**Our ref:** AN/2023/135033/01-L01  
**Your ref:** EN070008  
**Date:** 11 January 2023

**Application by Chrysaor Production (UK) Limited for a Development Consent Order (“DCO”) for a 55km underground pipeline for the transport of Carbon Dioxide from the Immingham industrial area to offshore storage – the Viking CCS Pipeline (“the Proposed Development”)**

- 2.2 We have reviewed the Development Consent Order (DCO) application, Environmental Statement (ES) and supporting documents submitted as part of the above-mentioned application, following notification of its acceptance for Examination on 22 November 2023. Our comments below are presented using the document references and ES Chapter headings relevant to our remit.

FIGURE TITLE
Figure 1 (1 of 3)
Source Protection Zones and Drinking Water Safeguard Zones (Groundwater)

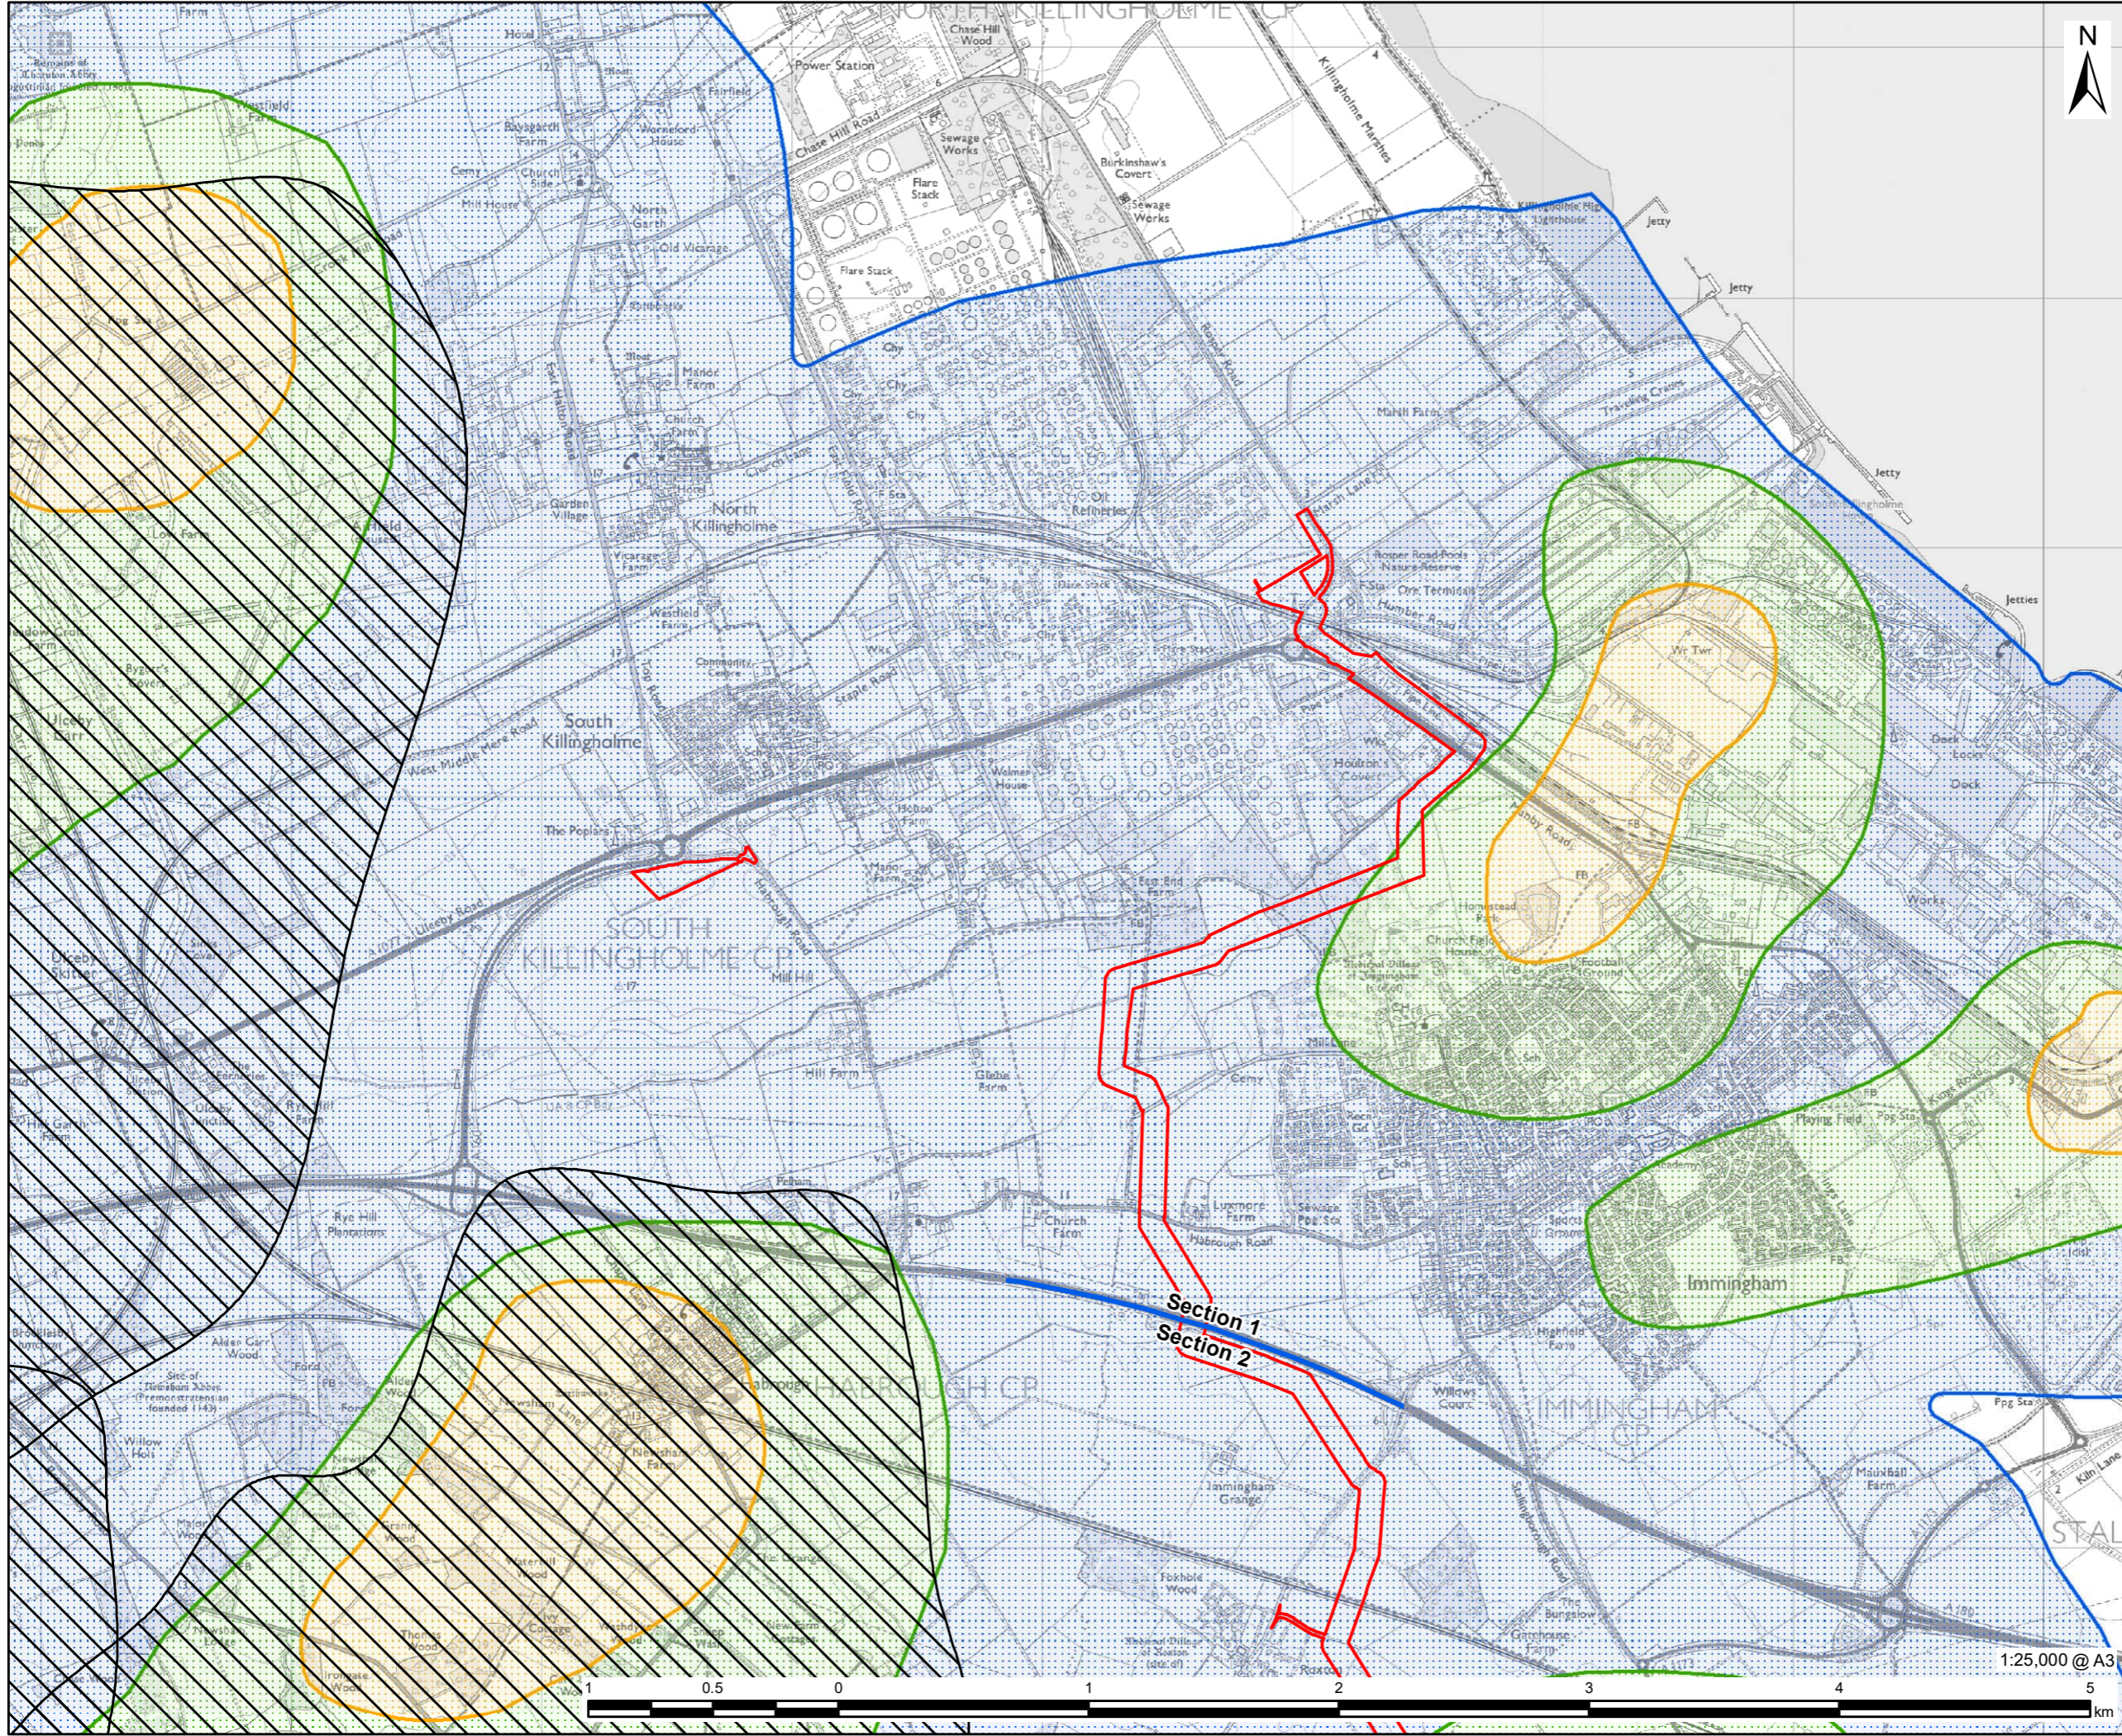
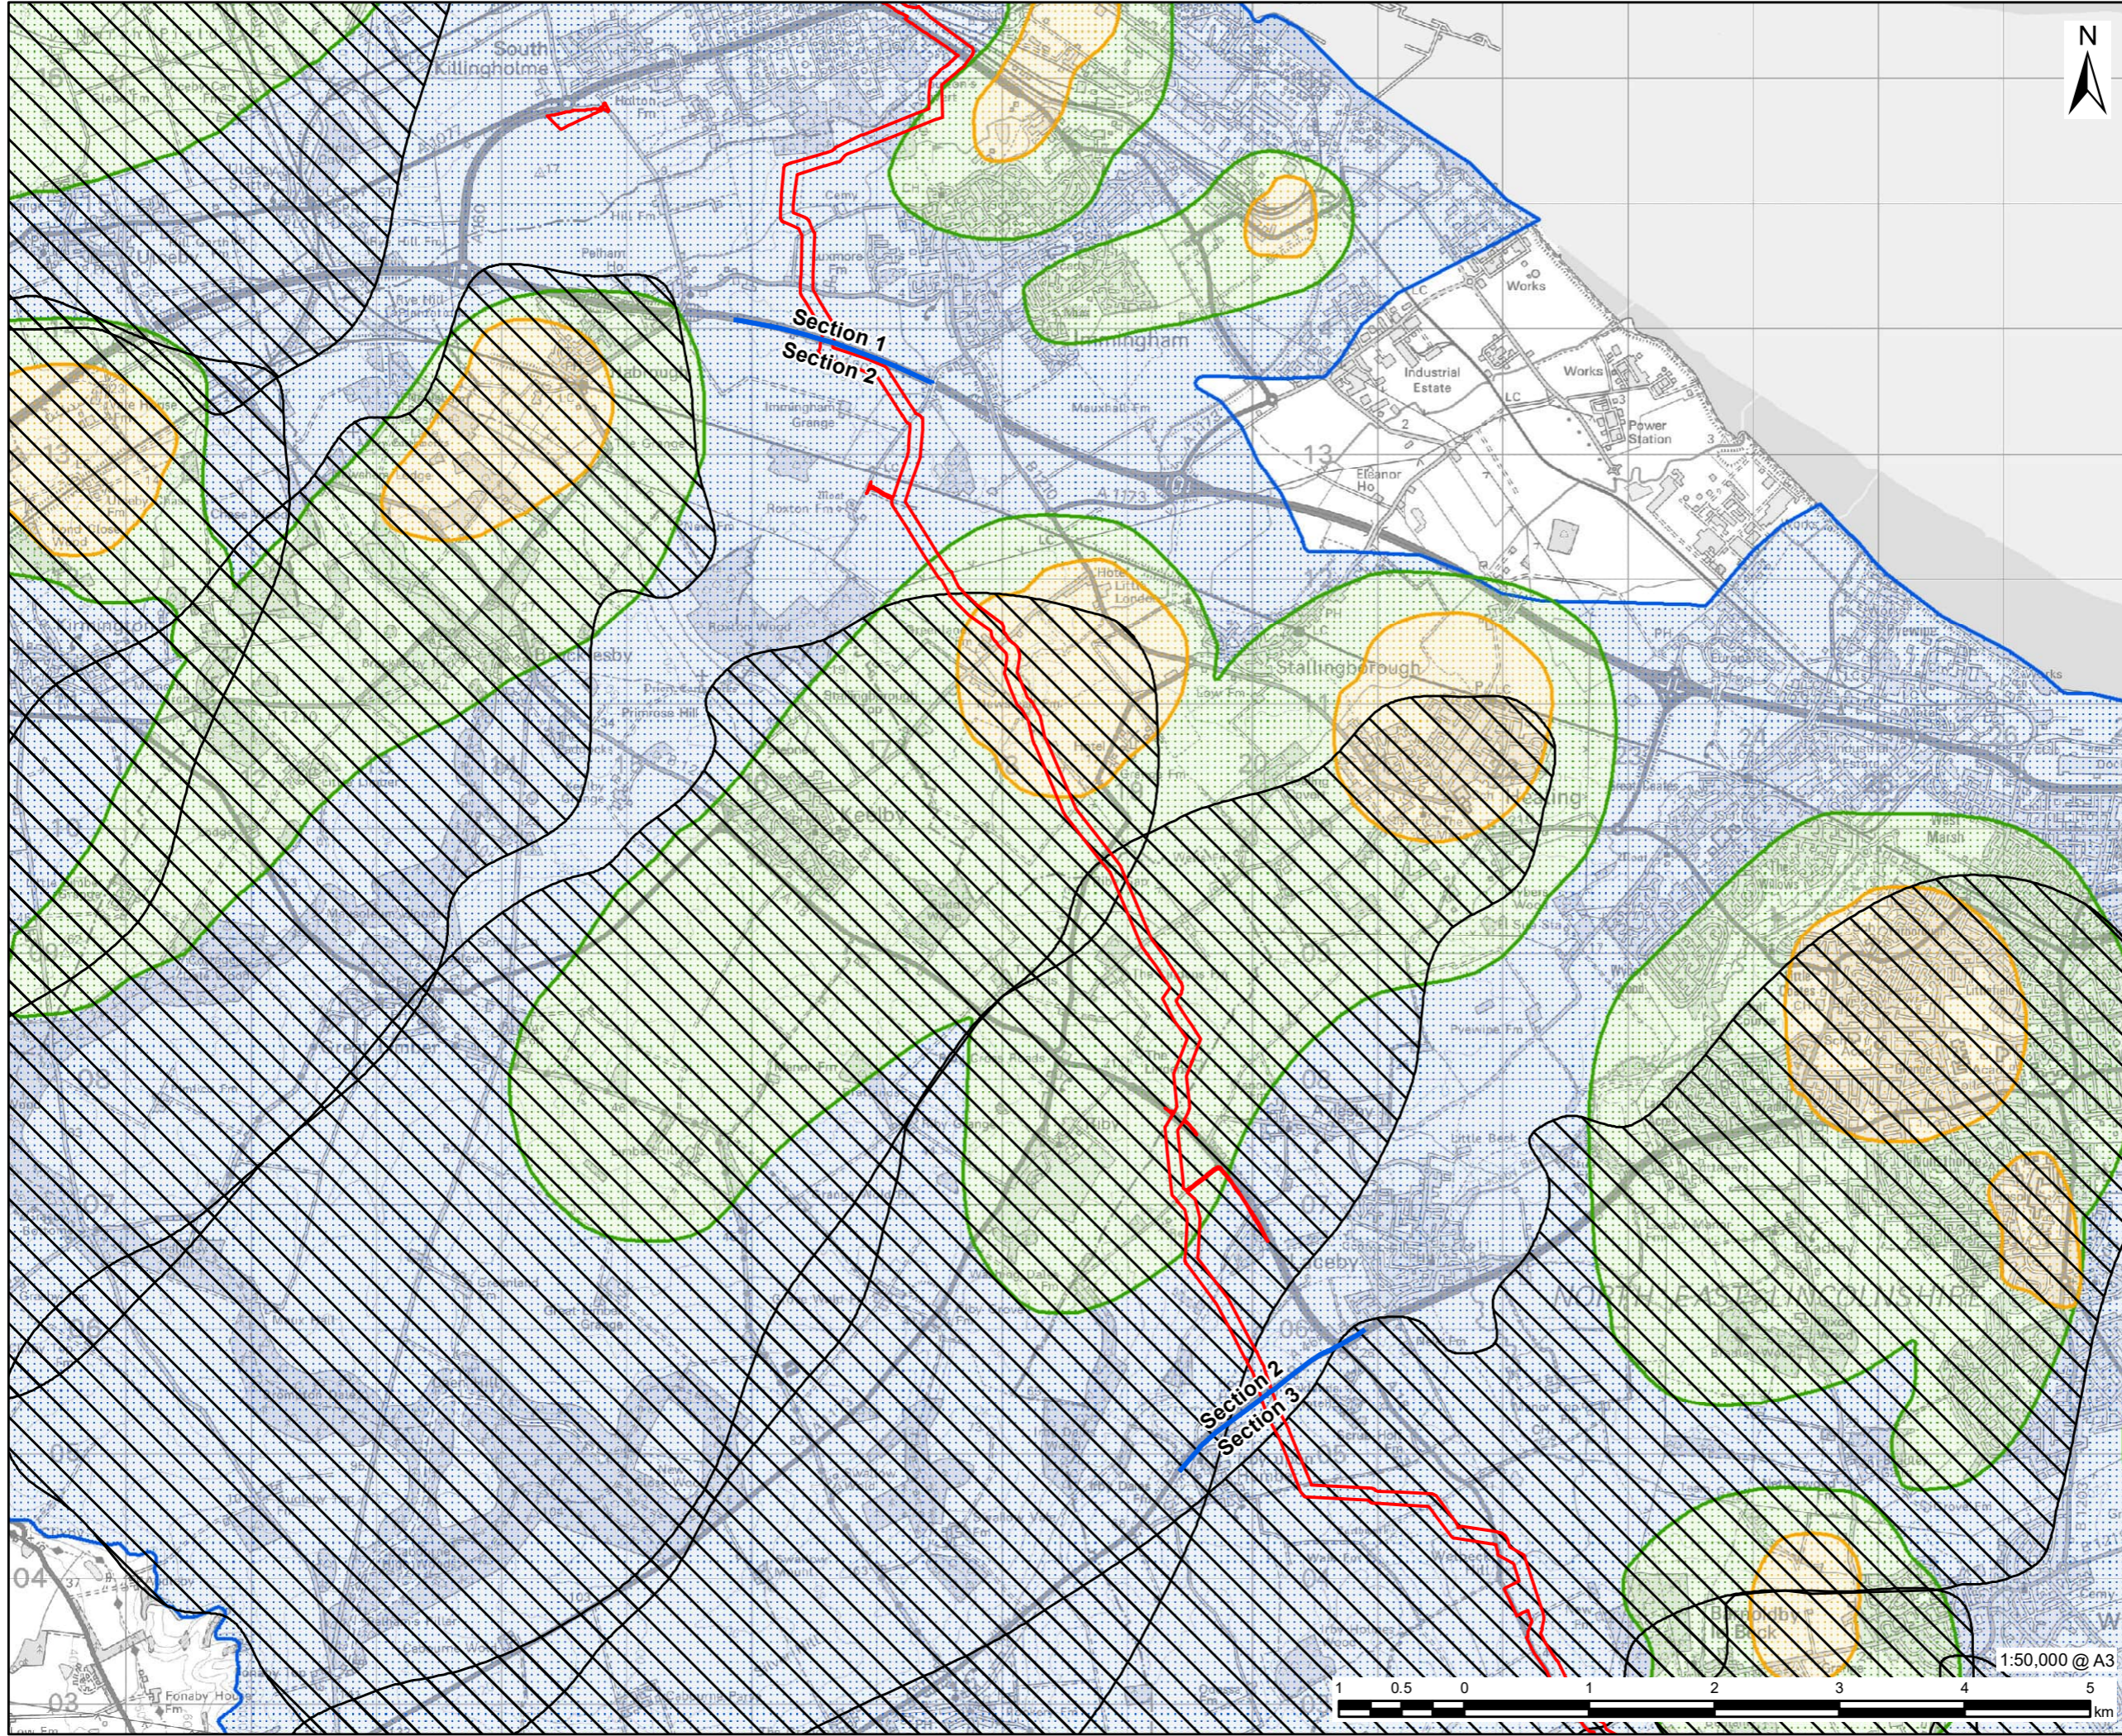
- 6.5 Section 1.3.2 states that groundwater safeguard zones are meant to be designated in Figures 1.2 and 1.3; these are not evident on the diagrams.
- 6.6 We note that in the absence of site-specific ground investigation data at this stage, the Hydrogeological Risk Assessment (HyRA) is considered to be 'preliminary' and will be reviewed and updated based on the findings of future ground investigations. We would like to be consulted on any future updates and believe this is secured through mitigation measure E3 in the draft CEMP (subject to our request to be a specific consultee to the final CEMP discharge).
